**From:** Paul Troop [REDACTED]  
**Sent:** 25 October 2023 06:21  
**To:** Planning  
**Cc:** White, Joy - Oxfordshire County Council; Catherine Hickman  
**Subject:** 22/01340/OUT

We also have serious concerns about the design of the access roundabout which, as currently conceived, is completely unsuitable for walking and cycling and would serve to exclude almost all potential pedestrians and cyclists as well as posing serious safety risks. We would expect to see segregated pedestrian and cycle paths, horizontal buffers from the motor vehicle traffic, and priority crossings for active travel over each arm, such as parallel or toucan crossings (depending on design speeds).

**Figure 2.2 – A43/B4100 Baynards Green Roundabout Improvement Scheme**

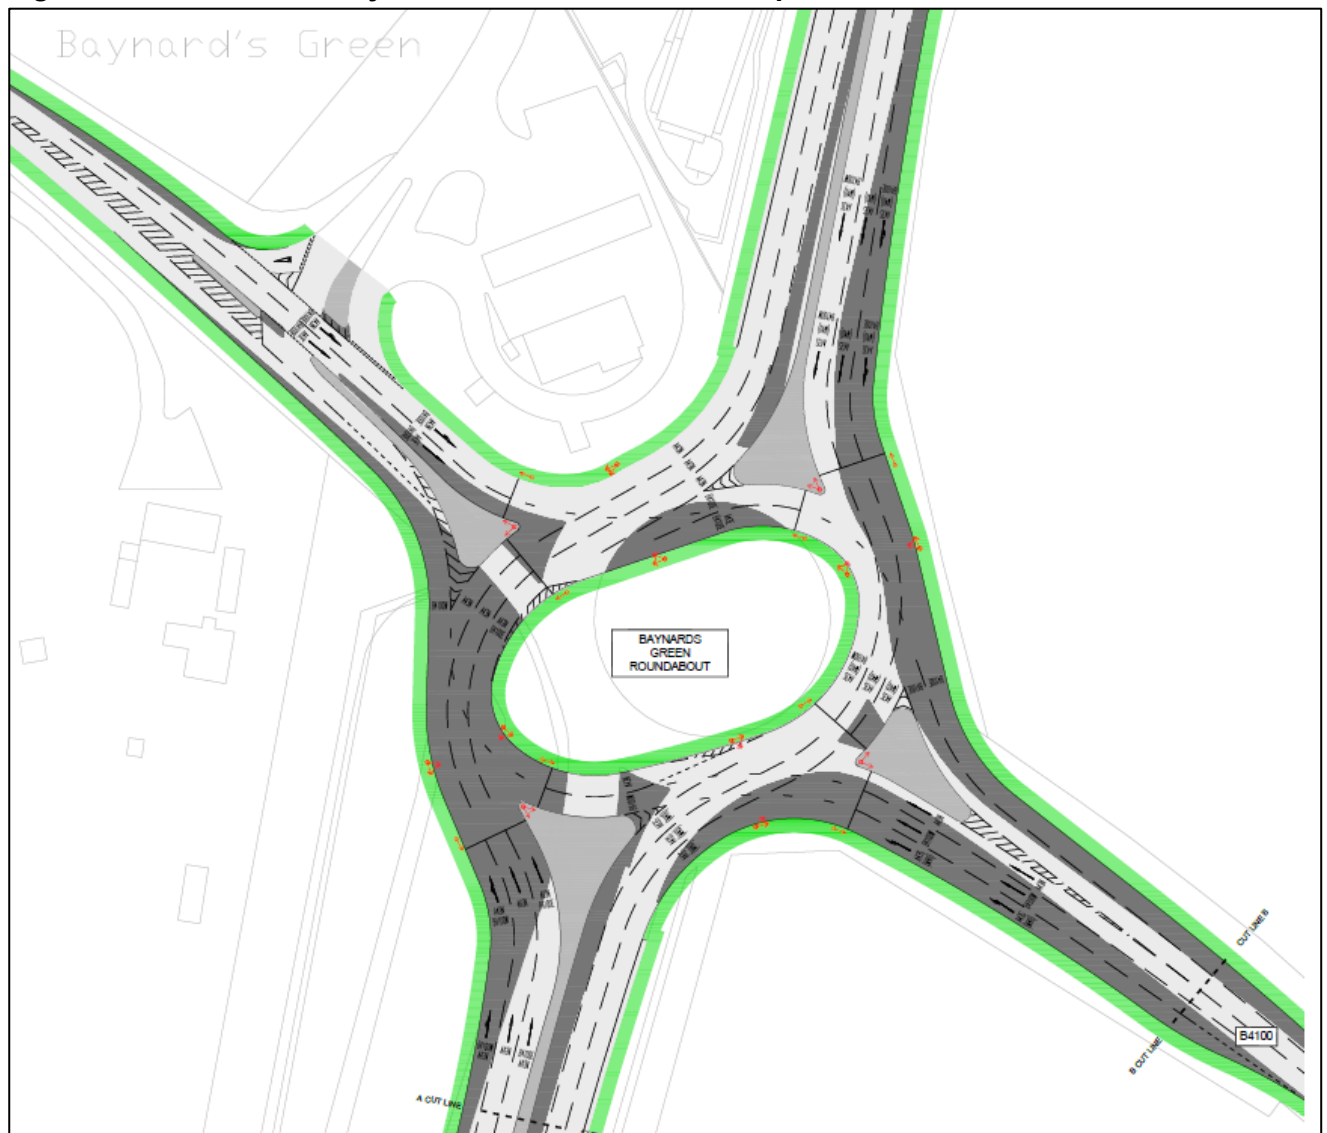
Controlled crossing upgrades would also be required at the Baynards Green roundabout to ensure safe and convenient connections for those arriving by foot or by bike from other directions.
